Planning Application Weekly List W/7/08 - Land at junction of Burpham Road and The Street
Warningcamp

Key Plan 1:1250

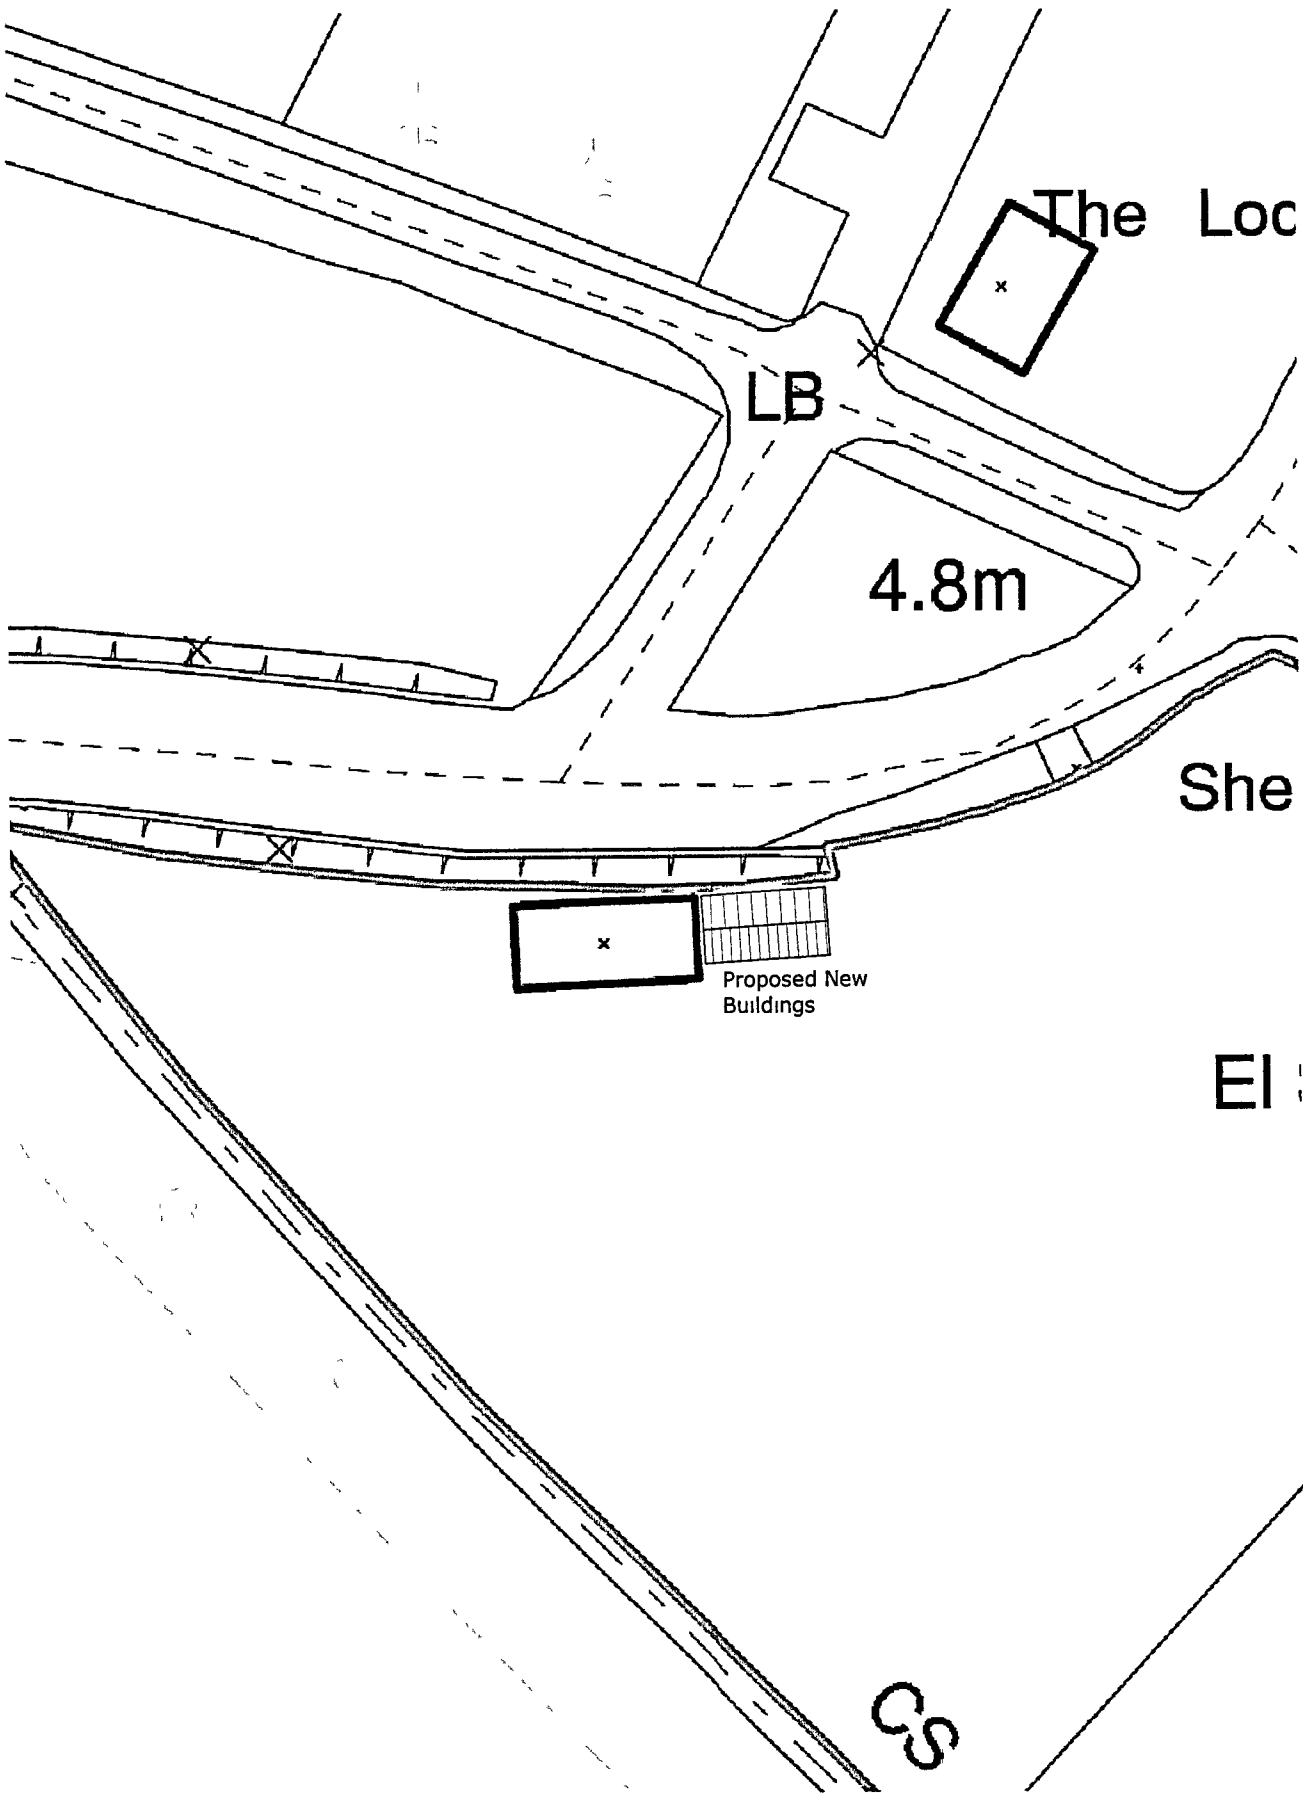
1. The existing hedge adjoining Burpham Road should not be interfered with either by the new building or during the construction works.
2. It is felt that as a condition of the planning permission the applicant should provide off street parking. At present the applicant parks her van beside the gate into the field where it causes a major traffic hazard to cars wishing to turn into Burpham Road from The Street, particularly as it is difficult to see vehicles coming from Burpham.
